25 Pleasant Cove Lane

Mon, Aug 8, 2016 at 3:04 PM

SOSNIK COTTAGE  
 TREE REMOVAL PLAN  
 JULY 22, 2016  
 SCALE: 1/16"=1'-0"

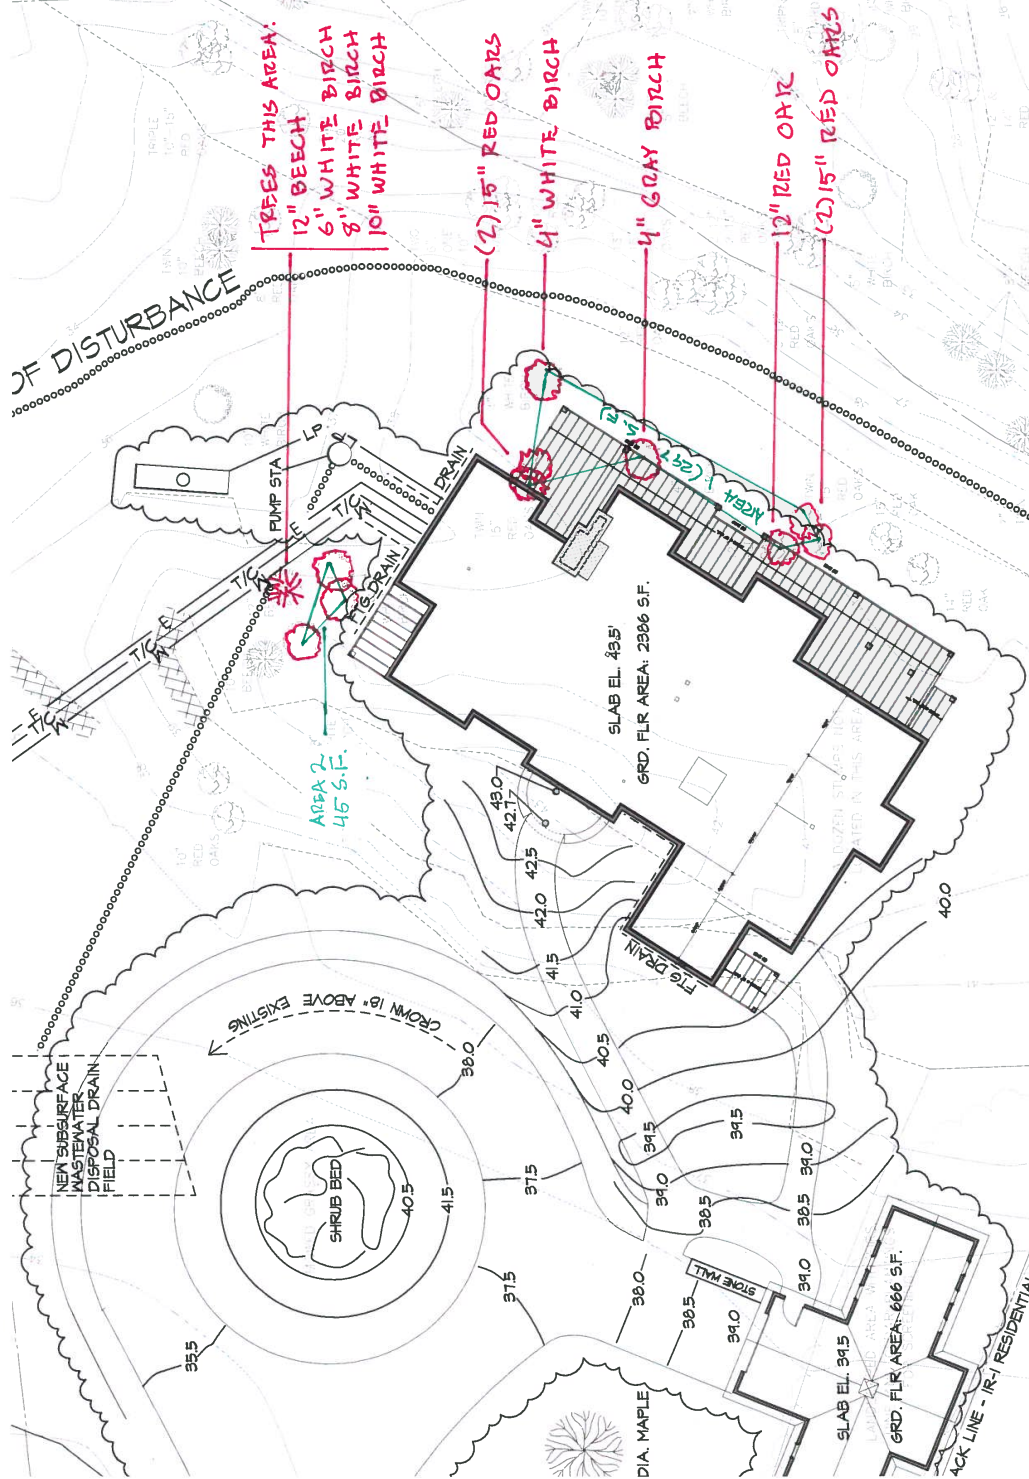
Thank you for this very thorough information. Is it at all possible to save one of the trees proposed for cutting, in order to keep the volume removal to 40%? The law does not really give me any leeway to approve an exceedance, even with some new tree plantings.

1) Can you provide what the approximate total size of cleared area on the lot will be, between 75' and 250' of highest annual tide? I tried to do a rough measurement using air photos and the plans, and I came up with about 16,000 square feet. Does this seem reasonable? The ordinance limits total cleared area to 25% of the lot area. So for a 70,494 sq ft lot, the cleared area cannot exceed 17,623 sq ft. This is measured between tree crowns.

2) On my question #3 in the last e-mail, you provided the total volume of the remaining trees to be removed (approximately 11 trees) in the 75'-250' zone. However, to confirm compliance with the clearing standards, we have to include anything that was removed in the last 10-year period. In reviewing the air photos on Google Earth, it looks like the primary cleared area has existed since at least 2003, so we can exclude that. However, between 2014 and 2015, it looks like a block of land was cleared in order to create a larger opening for the new house. Can you include the those recently removed trees into your volume calculation? I am not sure if you have any data on what was removed, but perhaps you can provide an estimate of what was likely to be there based on the surrounding vegetation? We also need to know the total volume of trees that existed within the 75'-250' zone prior to these removals, so we can confirm that the total removed in the last 10 years does not exceed 40%.

Thank you for your response. We propose to cut only trees #32, #34, and #35. That will leave us at 38.8% cleared.

Thank you for your help on this. After receiving your email, we did a complete inventory on site of the trees within the 75'-250' setback. We measured both the existing trees and the stumps that remained from the earlier cut. I am attaching a site plan and spreadsheet showing the trees measured and their sizes. The results showed that 36% of the basal tree area within the zone was removed during the past ten years. To build the house we need to remove five additional trees, which puts us at 41% cleared. We propose to mitigate this by planting three new oak trees within the setback zone. We hope that this satisfies the requirement.

Regarding your first question, 16,000 square feet sounds accurate.
